Historic England

30 September 2025

**Arrangements for Handling Heritage Applications Direction 2021
& T&CP (Development Management Procedure) (England) Order 2015
& Planning (Listed Buildings & Conservation Areas) Regulations 1990**

**HUDDERSFIELD OPEN MARKET, BROOK STREET, HUDDERSFIELD, HD1 1DY
Application Nos 2025/92444 & 2025/92443**

Proposed Plan - Layout of self-contained units / hot food units

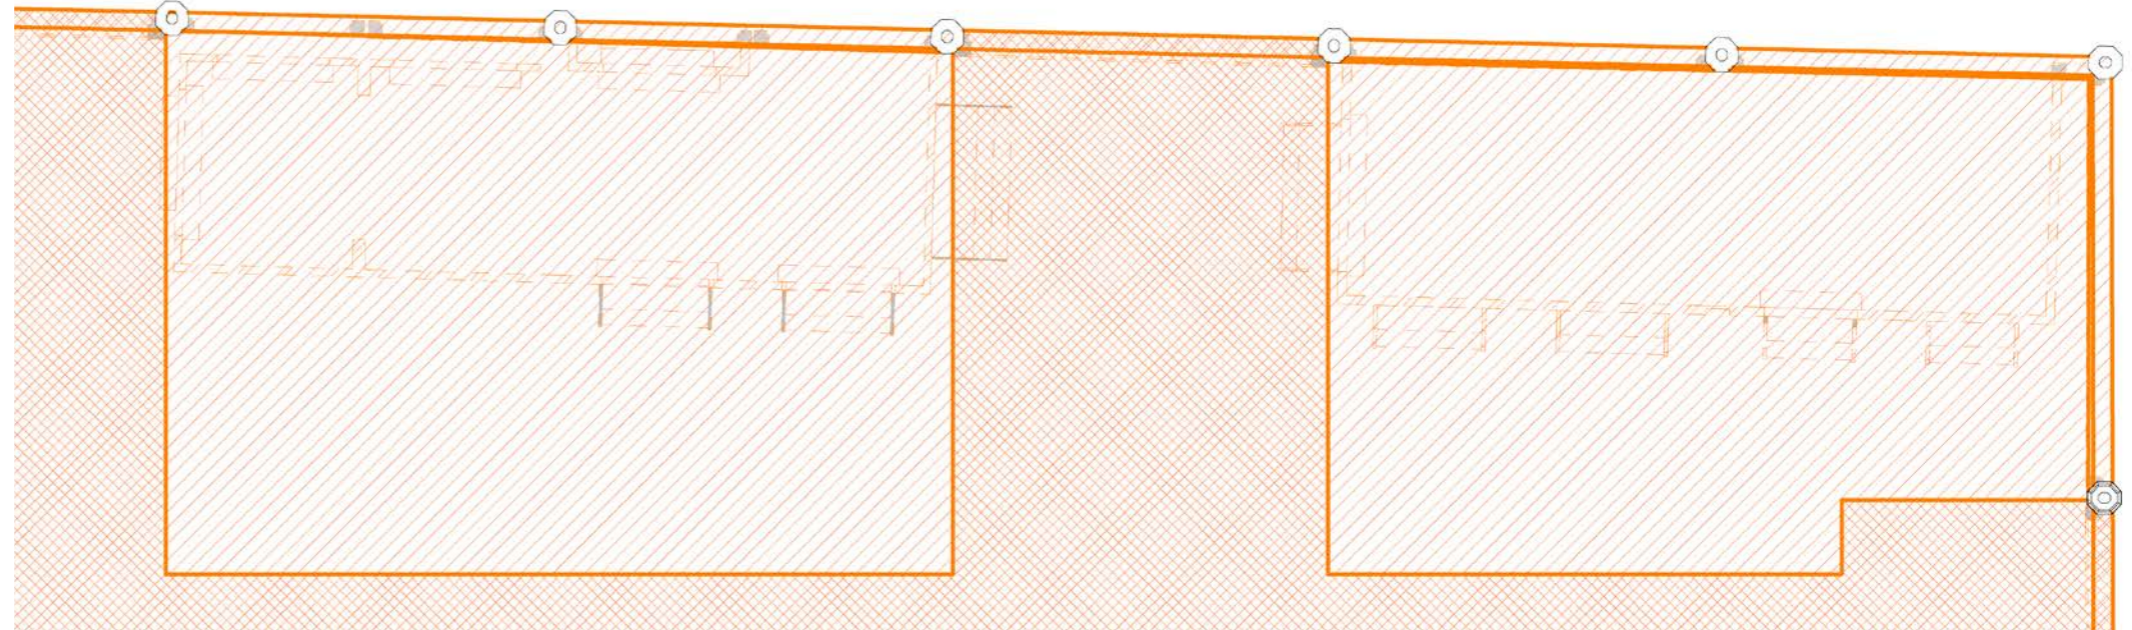
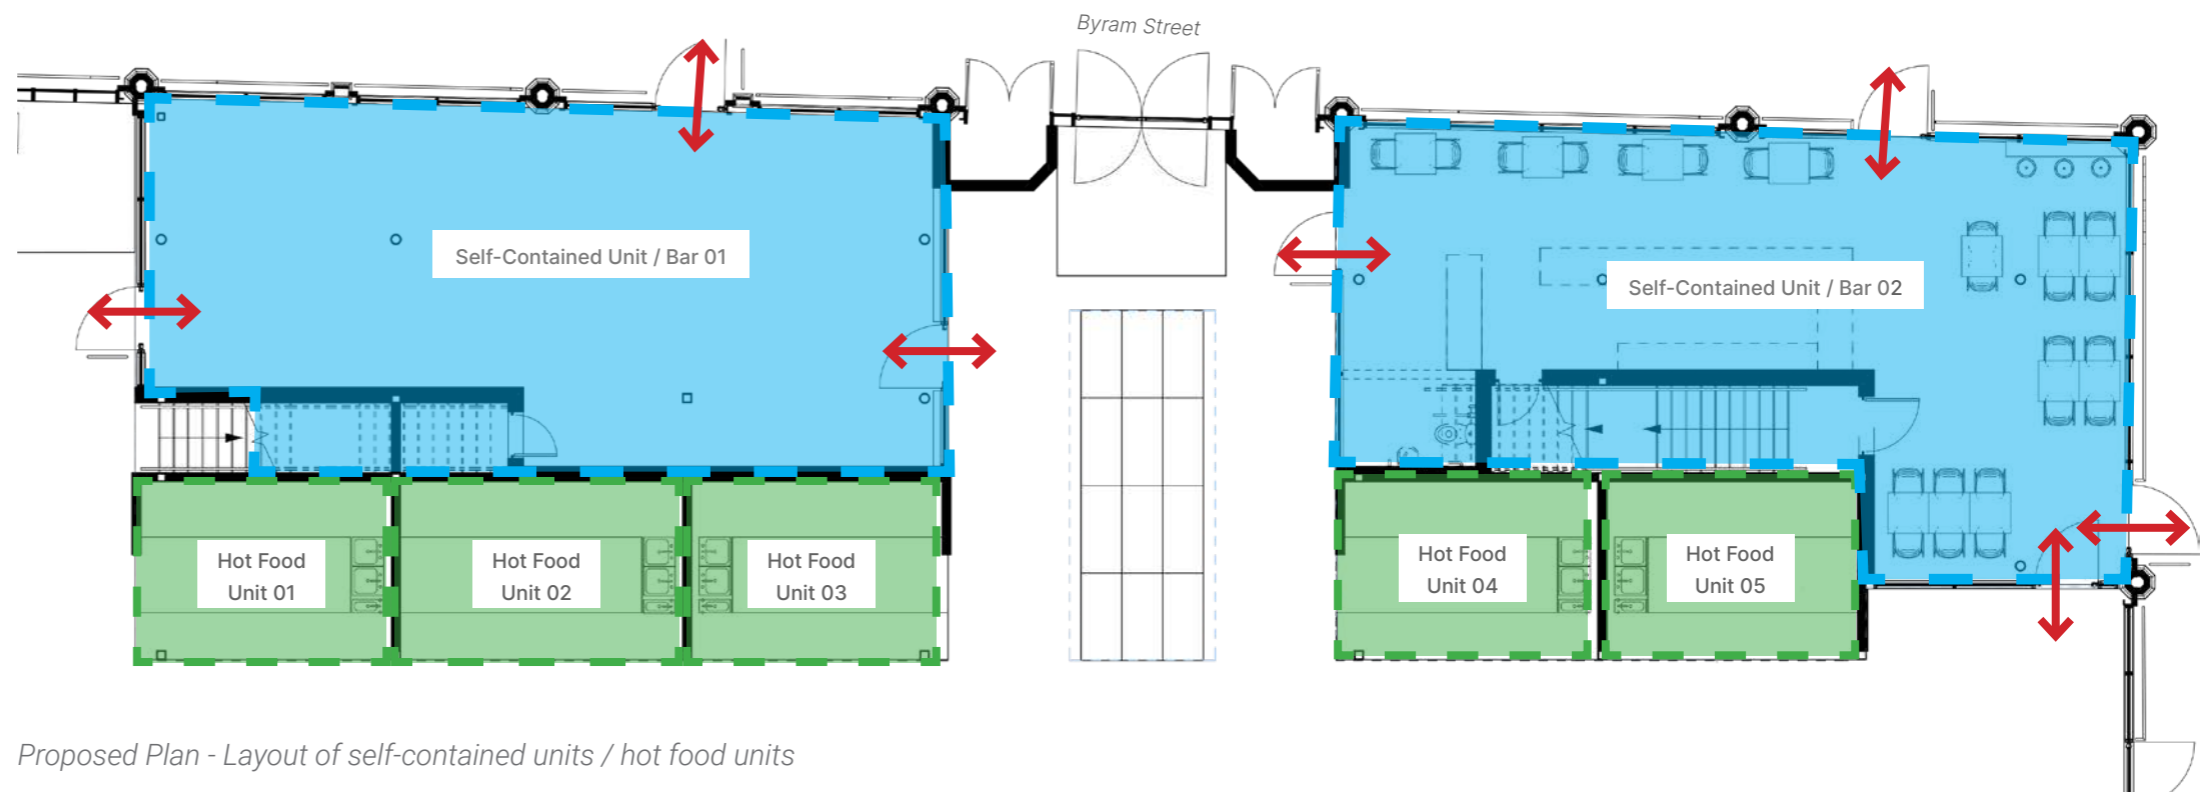
The additions of the self-contained units will cause some harm to this significance through eroding some of the open space and contributing to some visual impermeability which modern additions presently have also contributed to.

There would be a small amount of harm to the significance of the listed building caused by the construction of the hot food counters with mezzanines which breaks up some of that sense of volume and openness. However, it is considered that these new units are well detailed and would provide a new offering for the market going forwards with a view that the market can achieve its goal of becoming a more flexible space whilst keeping its role as a market at its core.

Proposed plan of fixed units

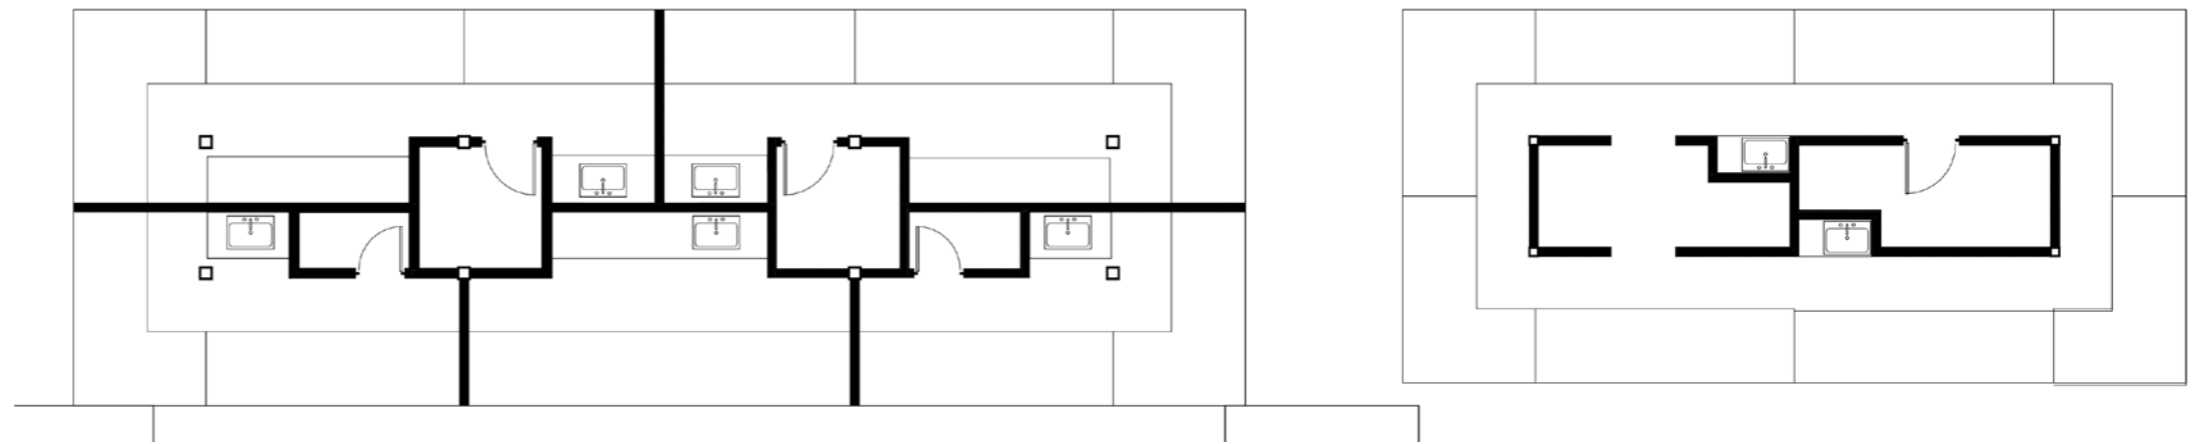
The proposals for the freestanding stalls and the fixed stalls will largely preserve this open character. The continued use of freestanding, collapsable market stalls continues the building's primary function thus therefore largely preserving the functional element of the building's significance.
